## CITY OF ALBUQUERQUE

May 6, 2019

**Re**: Water Authority Customer service and Operations facilities

6000 Alexander Blvd NE Traffic Circulation Layout

**TRAFFIC CIRCULATION LAYOUT**  
TCL-102

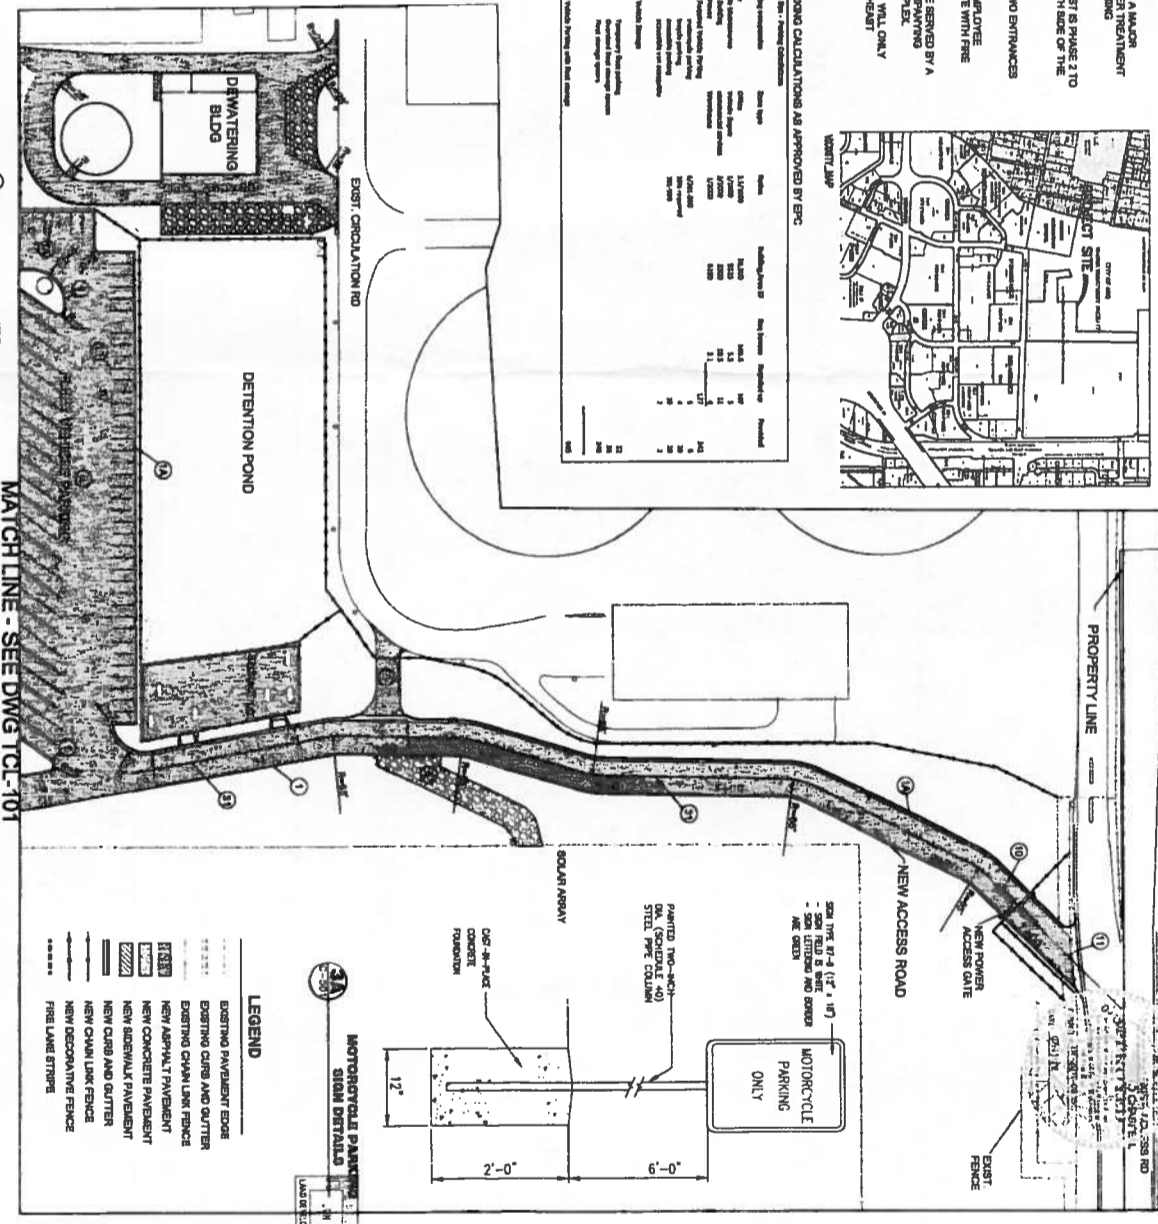
- 1. provide a copy of refuse approval.
- 2. Motorcycle parking spaces shall be designated by its own conspicuously posted upright sign, either free-standing or wall mounted per the zoning code.
- 3. Parking Calculation table shows bicycle rack. Please show the detail and the location of the bycycle rack.
- Please remove the fire lane stripings that are placed at the back of the parking spaces and submit the plans you submitted for fire one along with this TCL on your next submittal package.
- 5. Please show the dimesion of drive isle and parking spaces on the parking area by mission Ave NE. The dimensins are not shown.
